From: Michael Knappett [REDACTED]
Sent: 15 December 2014 12:29
To: Simon Davis
Subject: Land adjoining Sunnyside, Westergate Street, Westergate - AL/73/14/PL

Please find attached an amended site layout plan for your consideration.

Figure 1: Proposed Site Layout, with new Plots 1a & 1b shown within red line.

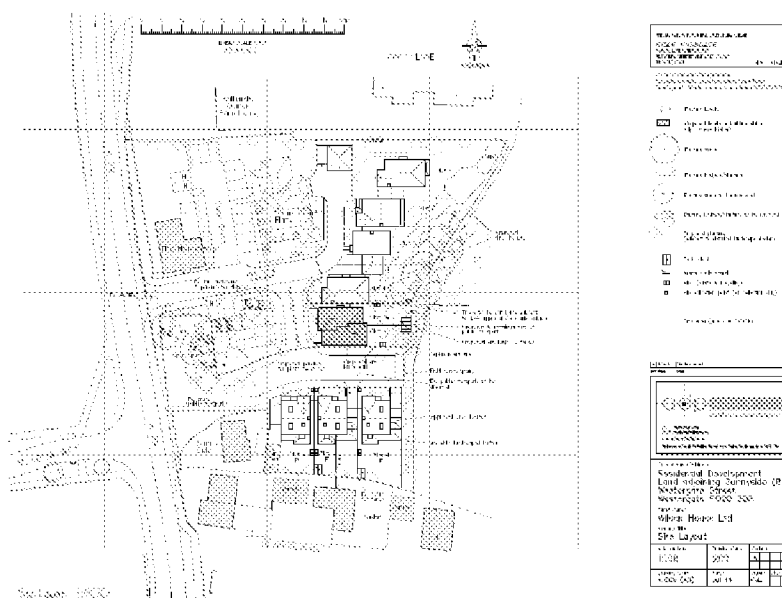
The siting of units 1a and 1b remains unchanged. The units are now enclosed to the front (west) and part along the southern boundary by a 1m picket fence. The rear garden for unit 1b has also been made slightly wider by moving the boundary between the two gardens northwards.

Plot 1a would still have a rear garden of 11.6m and Plot 1b would have 10.9m. The private amenity space now available for Plot 1a would be 85 sq.m and Plot 1b would be 76 sq.m. Plot 1a would satisfy emerging Policy D DM3 of the Arun Local Plan 2011-2031 Publication Version and Plot 1b would not fall too far short., but both properties would clearly provide useable private amenity areas.
